## **DEPARTMENT OF PUBLIC WORKS**

### **MEMORANDUM**

TO: All Staff  
FROM: Public Works Planning Review Team  
DATE: December 22, 2020  
SUBJECT: BL-20-00030 US Bureau of Reclamation

BOUNDARY LINE ADJUSTMENT FOR U.S. BUREAU OF RECLAMATION
DRAWN BY: KDB DATE: 6/1/2020
REV. BY: KDB DATE: 1/11/2021
PROJECT MANAGER: KDB
SCALE: 1" = 1000'
DRAWING FILE NAME: 1702303_BLA.DWG
CHK BY: SPJR
JOB NO. 17-023-03
SHT. NO. 1 OF 6

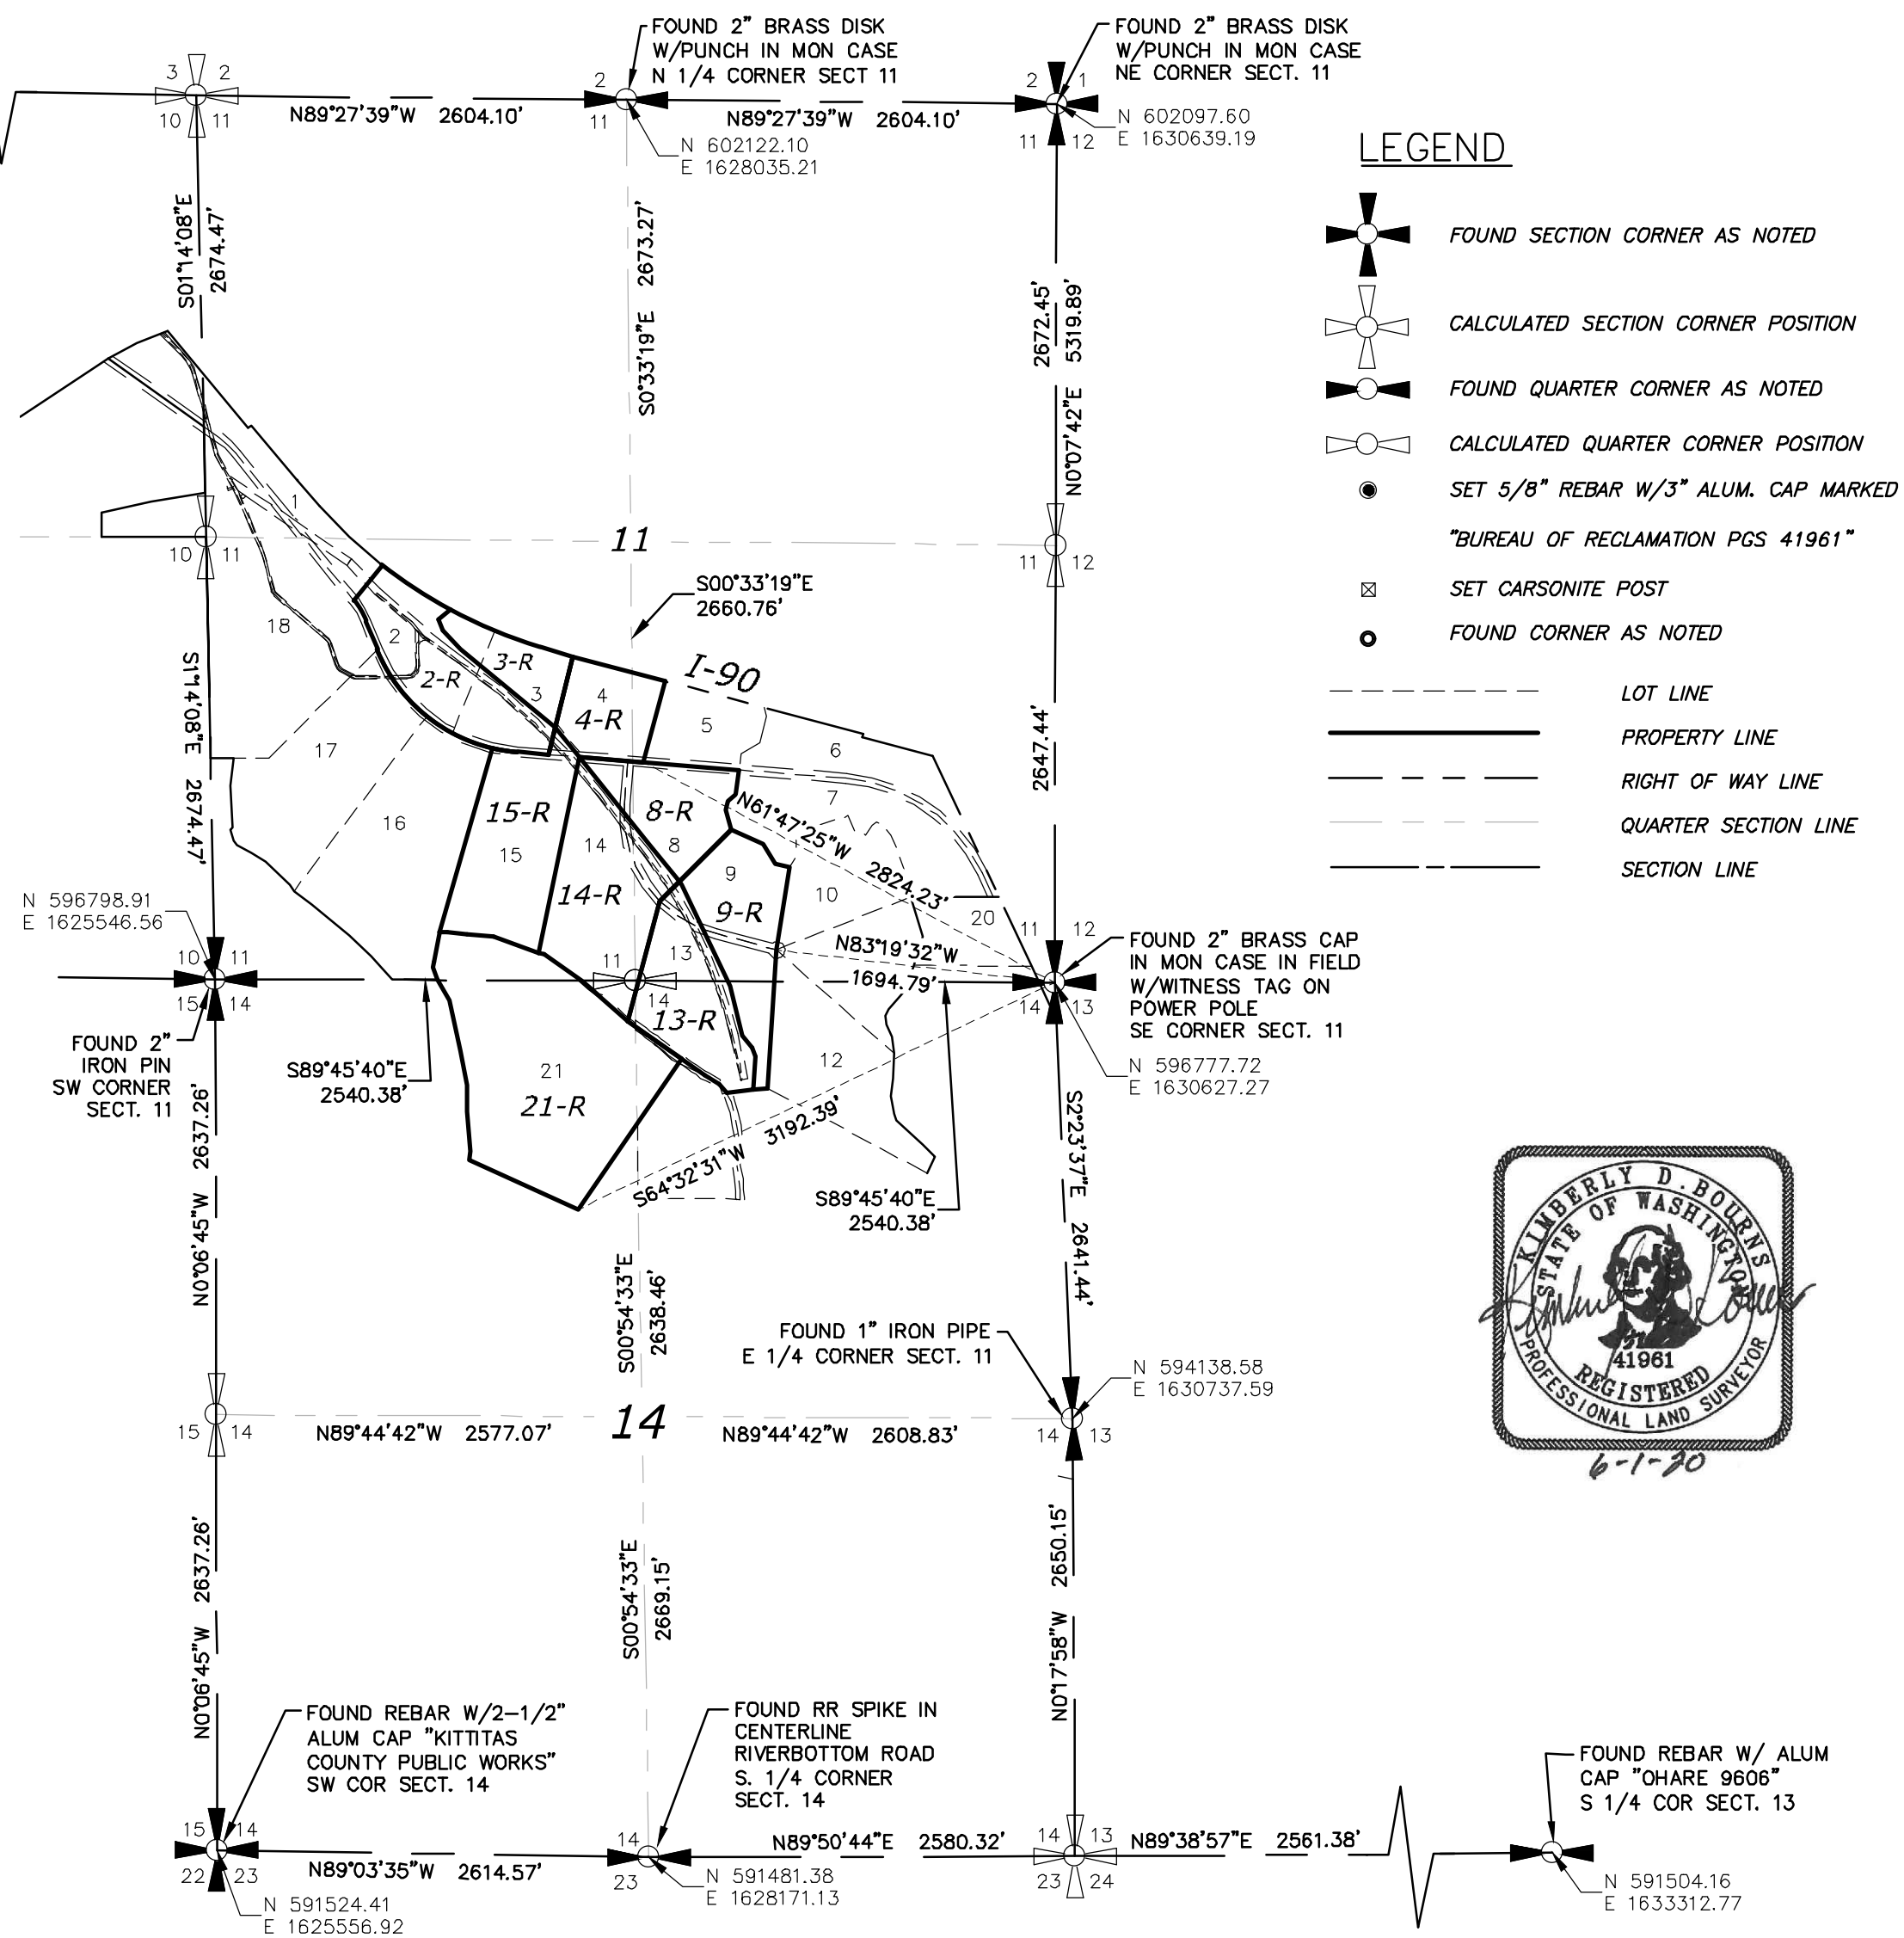
1. The survey narrative does not make reference to Lot 21, which is also revised as part of this BLA. The Narrative May also want to include reference to the County Application no. (BL-20-00030)

2. The Surveyor's Certificate lists Seattle City Light as the client.
3. The curve located on sheet 2, being the South boundary of Lot 2-R is awkwardly displayed. "Crows Feet" or similar symbology would help in clarifying the overlapping dimensions.

DRAWN BY: KDB	DATE: 1/11/2021	REV. BY: KDB	DATE: 1/11/2021	PROJECT MANAGER: KDB	SCALE: 1" = 150'
DRAWING FILE NAME: 1702303_BLA.DWG	CHK BY: SPJR	JOB NO. 17-023-03	SHT. NO. 3 OF 6

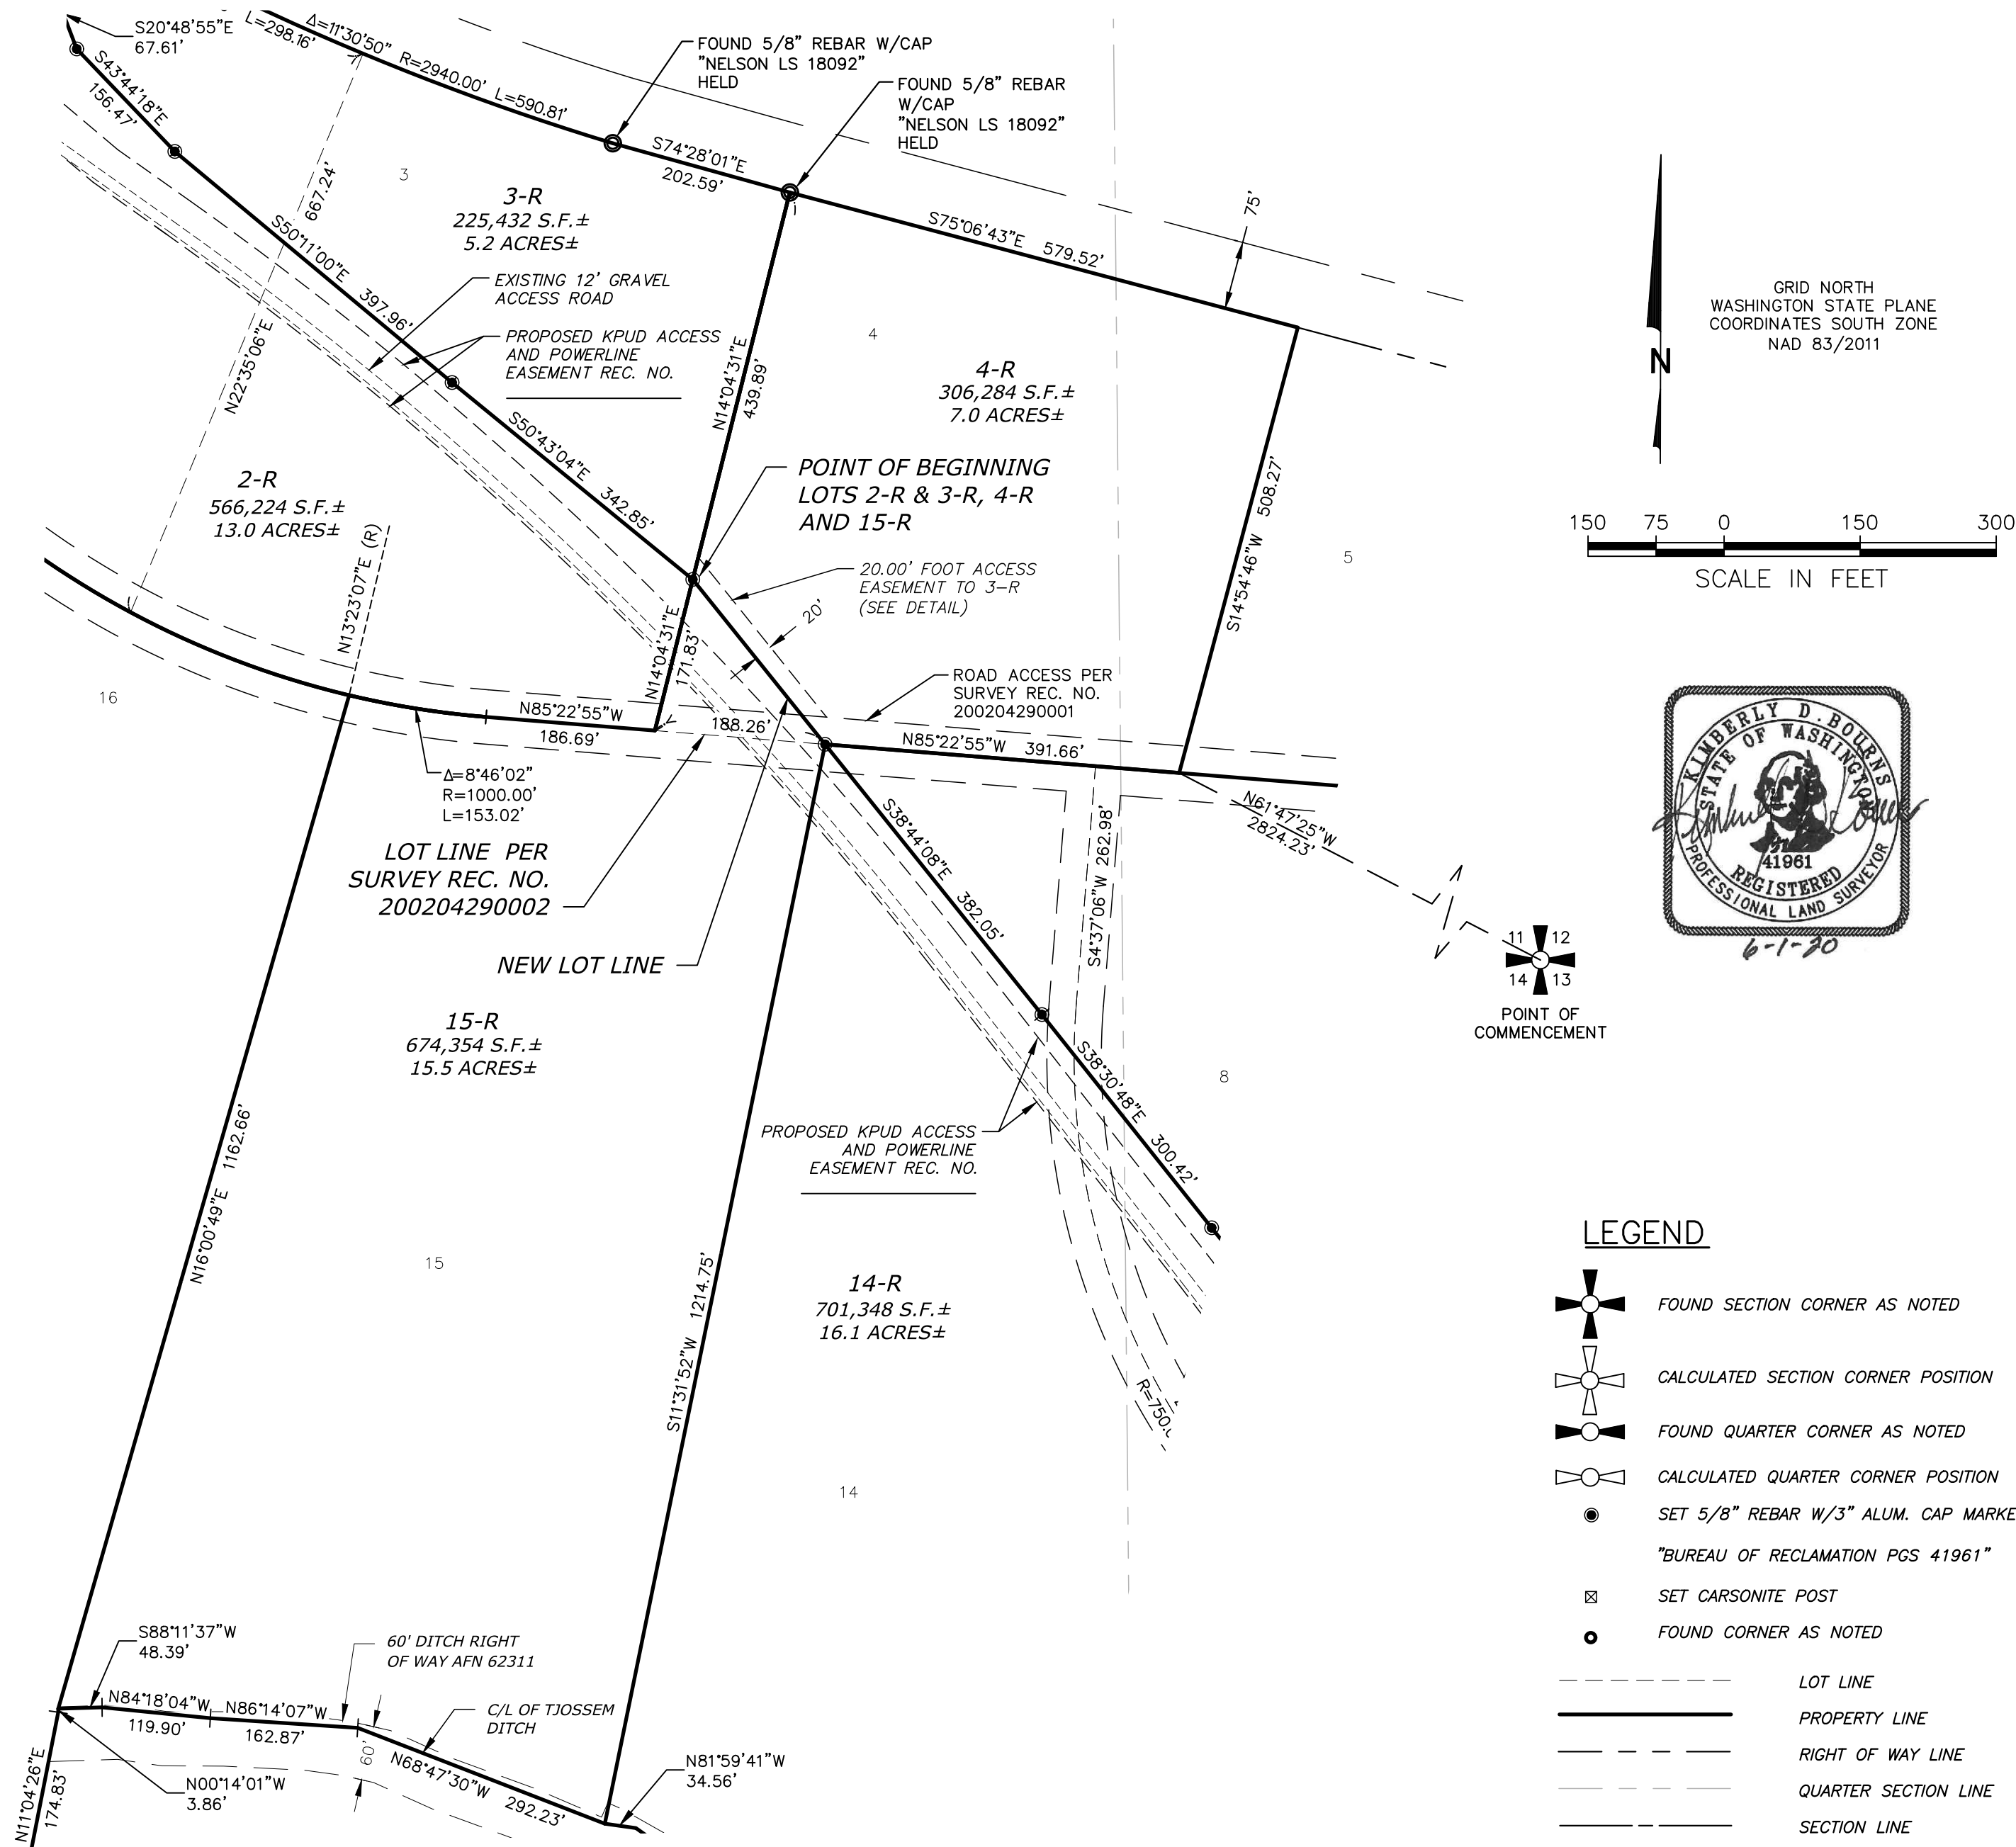
4. The bearing and distance of the NE'most line of Lot 15-R is not shown on Sheet 3. It can be found on 2.
5. While the entire BLA has been scaled to grid, there is no preamble addressing this in the legal descriptions of the lots. This should be addressed, as the legal descriptions NOT the survey create the parcels. A preamble to the legal descriptions noting the grid and scale factor, OR revising the legal descriptions to read: "Lot \_\_\_ of that certain survey recorded \_\_\_\_\_, in Book\_\_\_, Page\_\_\_ under Auditor's File No. \_\_\_\_\_, records of Kittitas County". The blanks would be filled in at time of recording.  
(While this self-referential description is not allowed in some places, it is allowed in Kittitas County)
